Department of Primary Industries

**IKEA Multi-Function Logistics Unit, Marsden Park (SSD_6954)
Response to exhibition of Environmental Impact Statement**

Comment by DPI Water

NOTES:
1. TEMPORARY BASIN HAS BEEN INCLUDED FOR THE CIRCUMSTANCE WHERE BASIN B IS NOT AVAILABLE

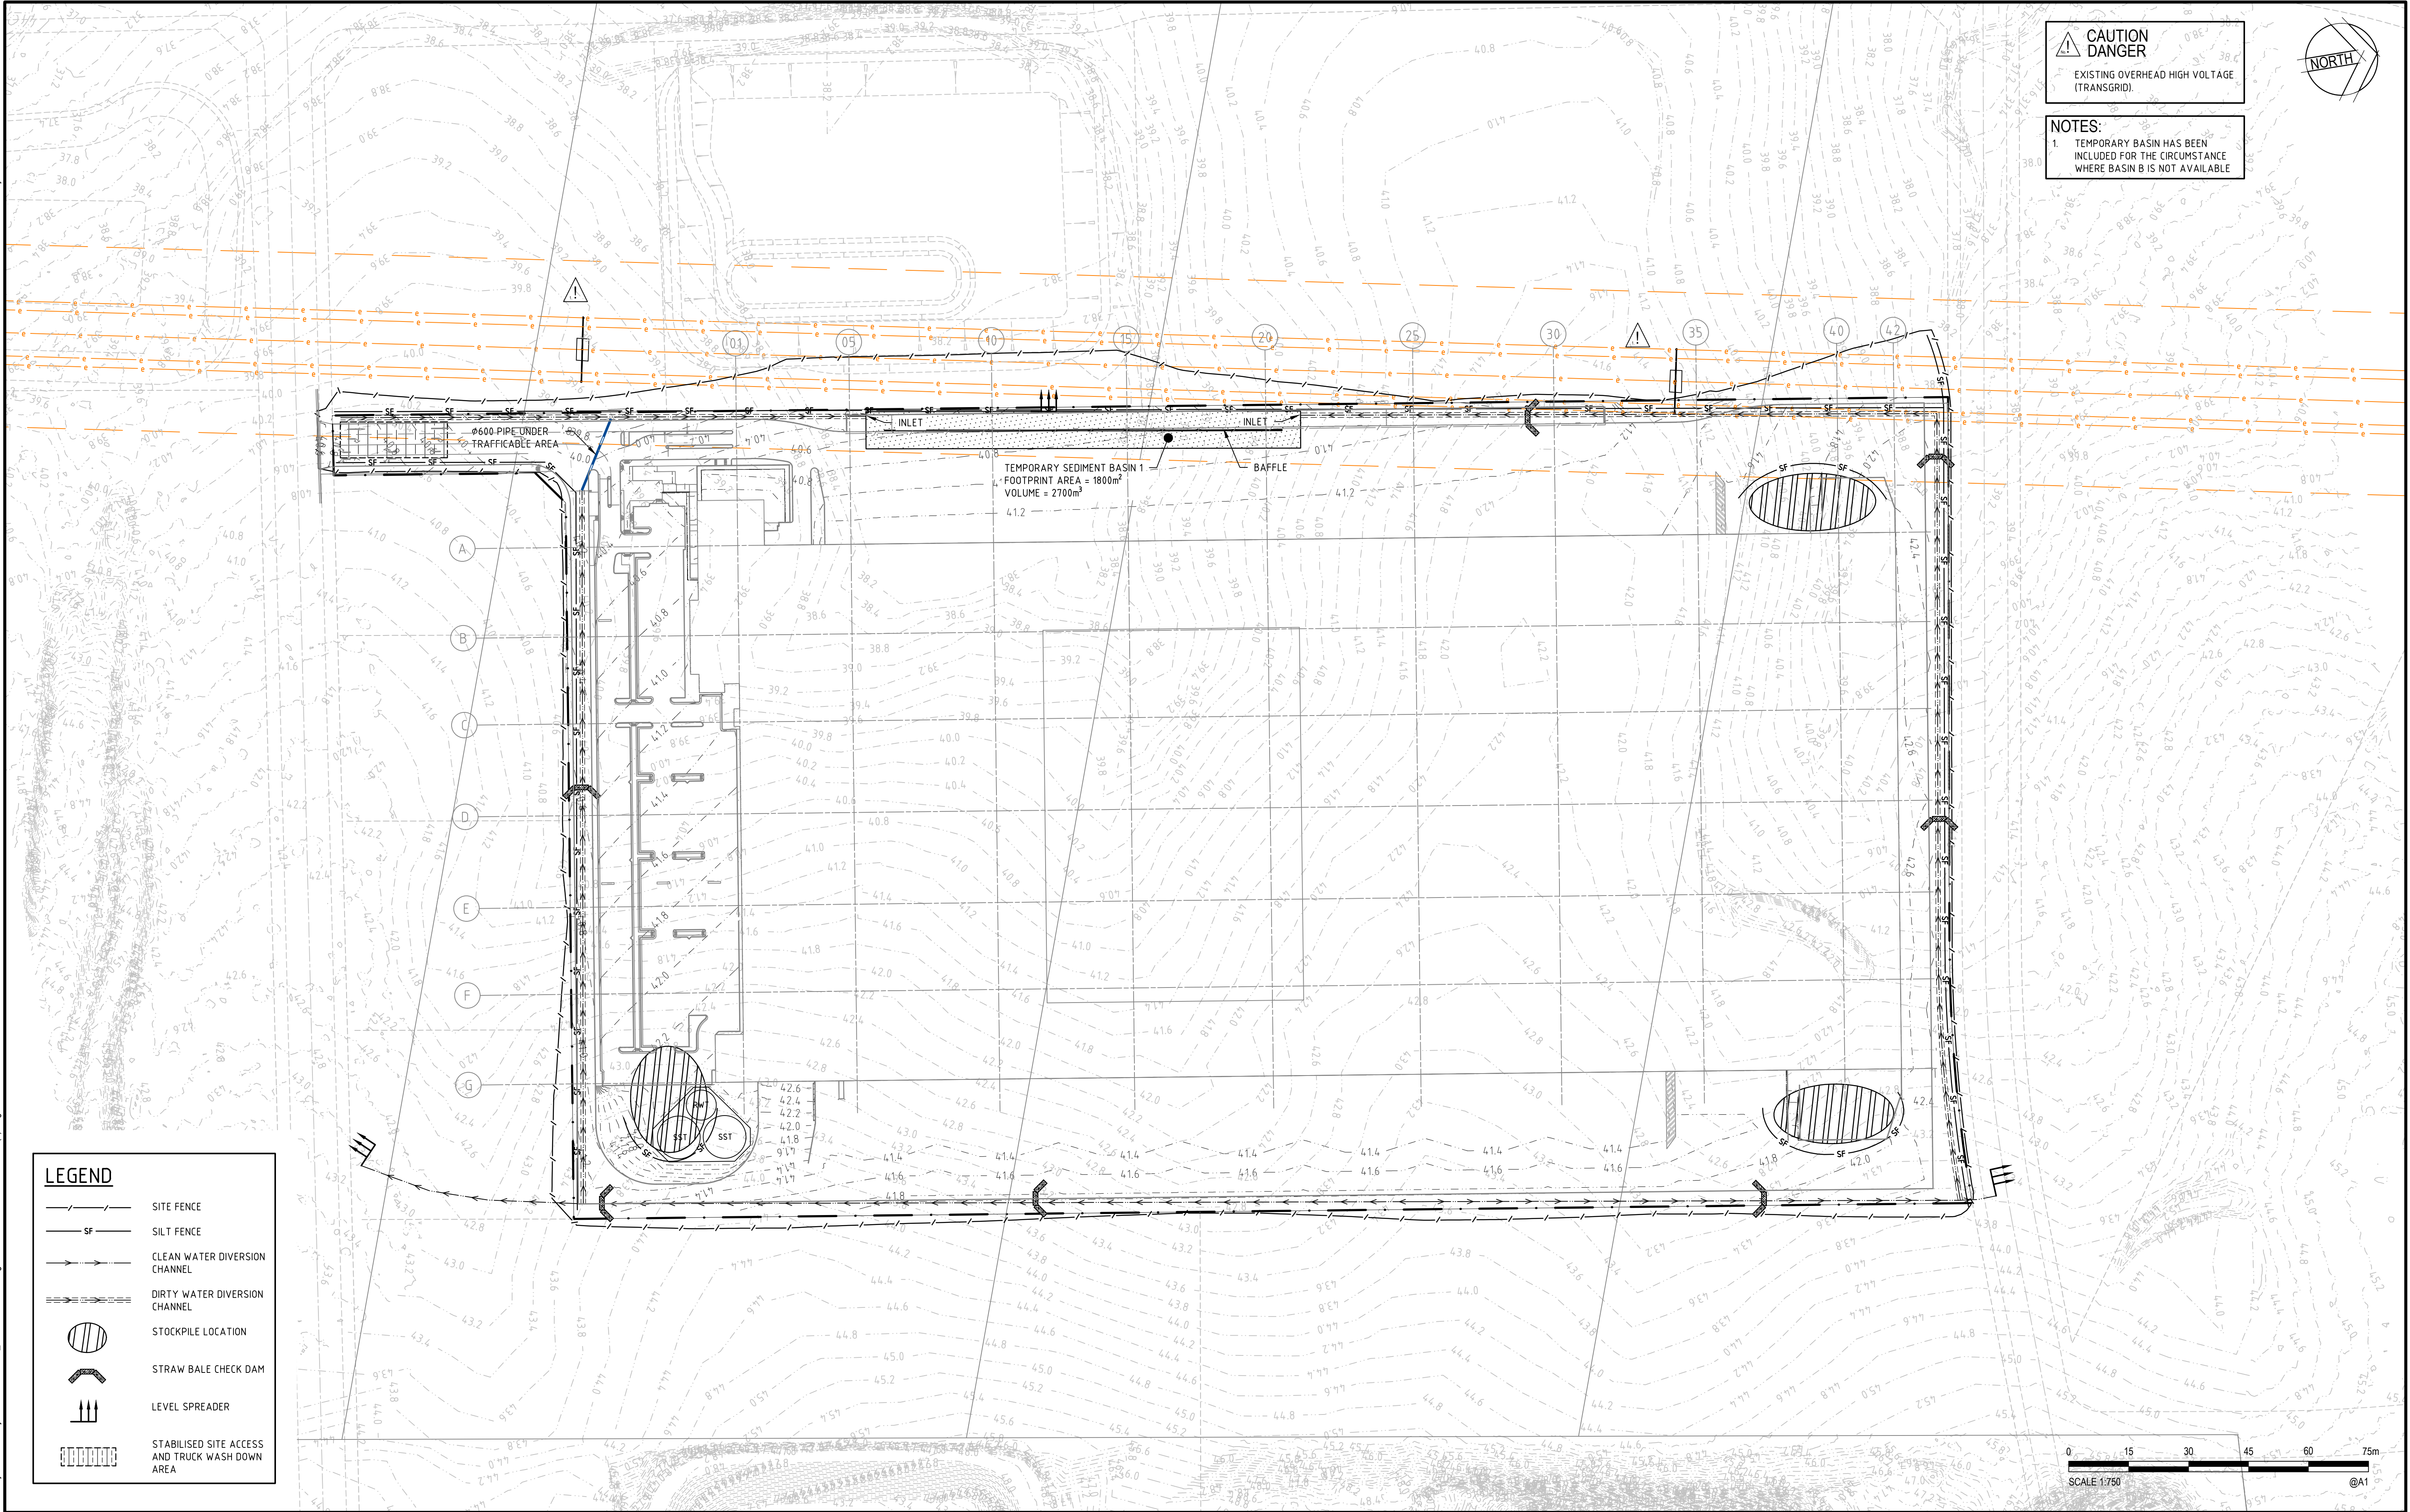
- the proposed stormwater detention basin/temporary sediment basin will be constructed prior to the clearing/bulk earthworks commencing on the IKEA site associated with the DA, or prior to any construction activities commencing with the IKEA SSD project.
- the bio-filtration basin will be constructed to treat runoff from the IKEA site during construction activities, or during the operation of the project. Bioretention basins require well established vegetation and details are required as to when the bioretention basin /swale will be constructed and when the vegetation in the basin will reach maturity and be fully functional in terms of treating runoff from the IKEA development.
